## **Thanet Extension Offshore Wind Farm**

Appendix 2 to Deadline 2 Submission: Applicant's  
Response to Written Representations on the  
theme of Ports/Shipping Routes

Date: February 2019

Sea Zones Plan – Reduction in red line boundary

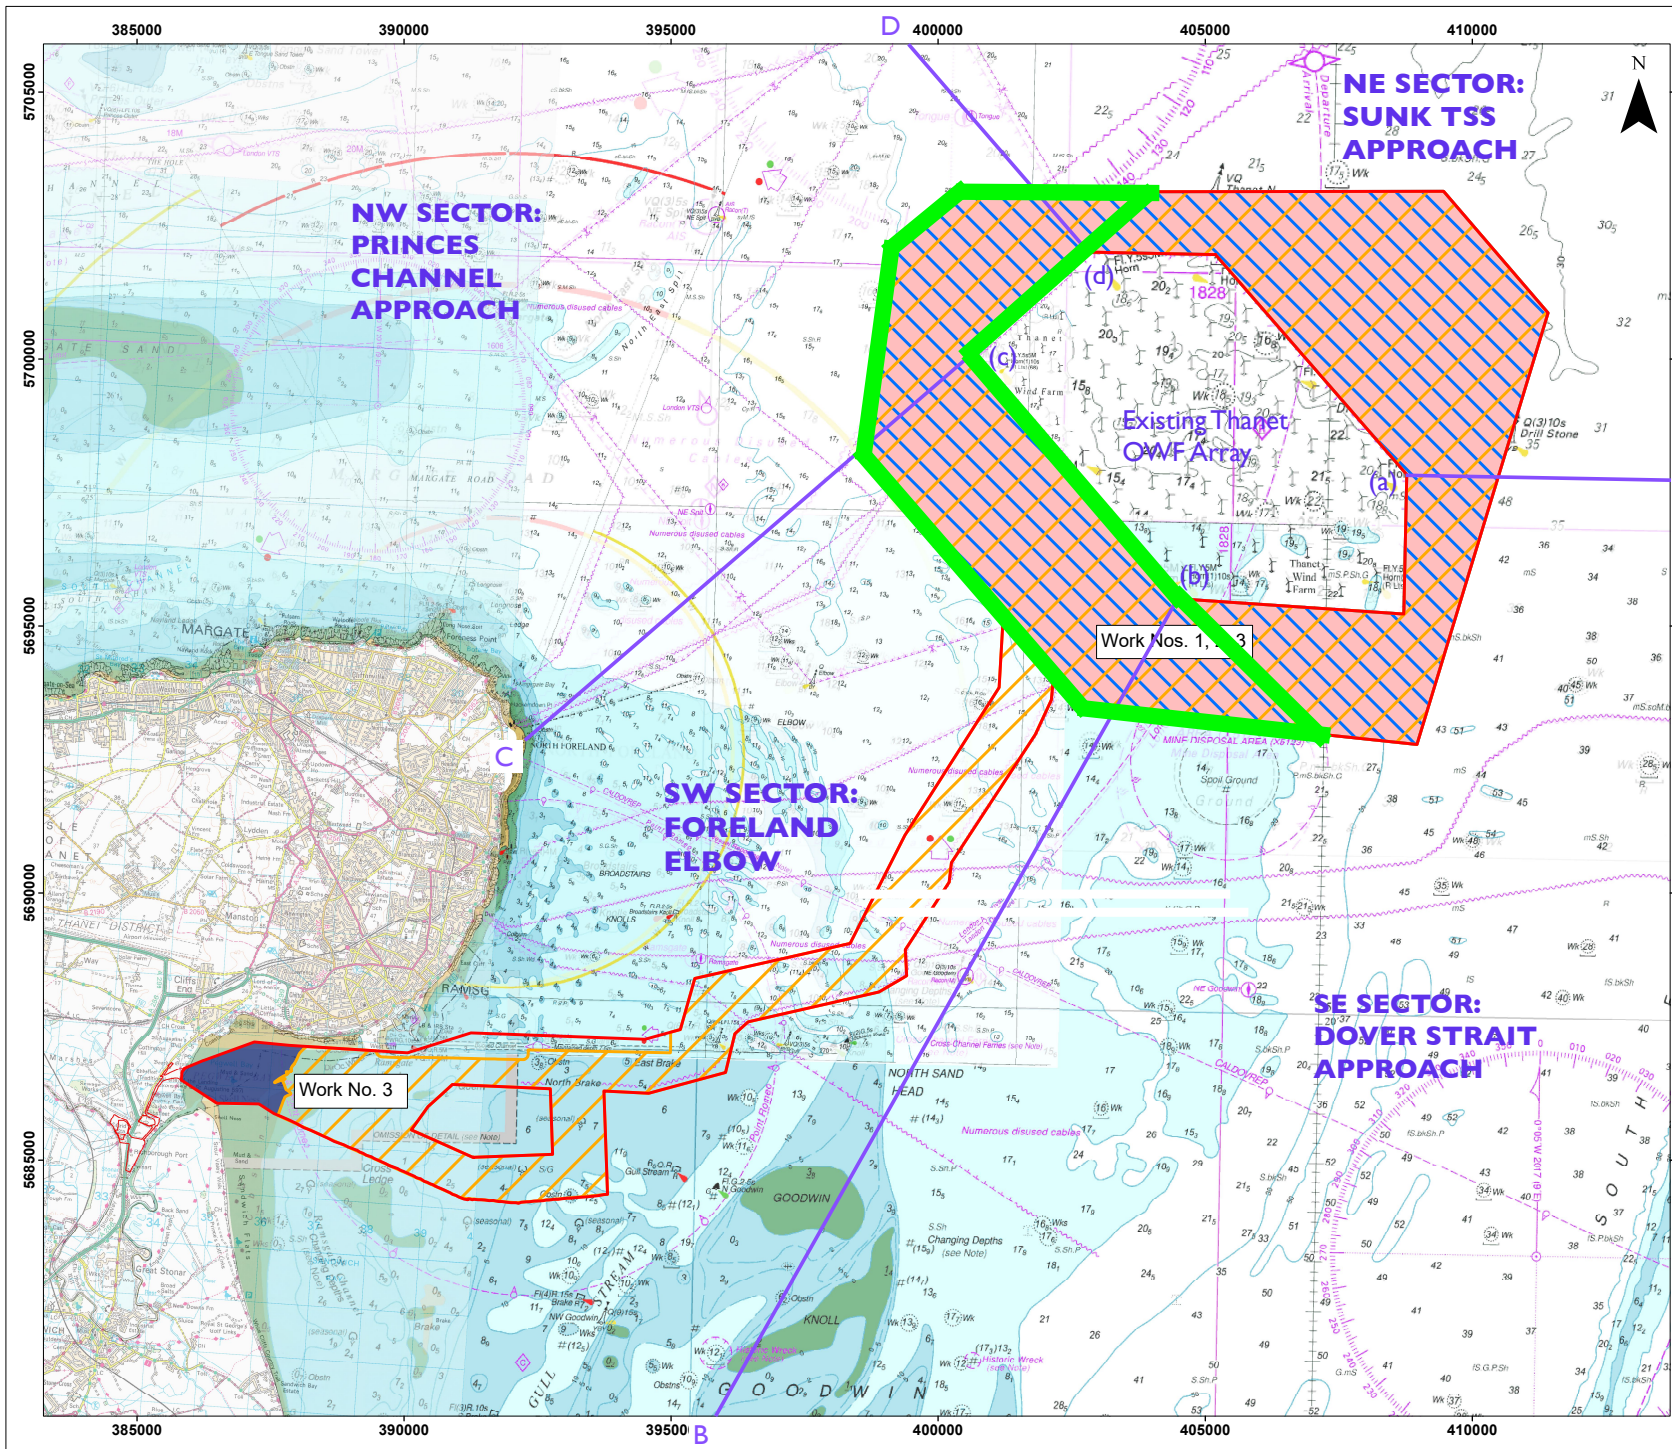
12 However, both PLA (REP1-142) and ESL (REP1-141) contest this value, stating a buffer of 1nm between a route and the proposed WTGs should be considered. This is neither evidenced by existing practise (vessels transit <0.5nm from the east of the operational Thanet OWF), or any specific PLA guidance documentation (received during consultation), and within PLA Statutory Harbour Authority channels is not evident.

- 13 It is the Applicant's view therefore, as set out in representations made during ISH2 by Simon Moore, active Master Mariner, the NRA (and associated studies), and the LPC that 0.5nm is a reasonable minimum distance by which the prudent mariner would expect to avoid a wind.
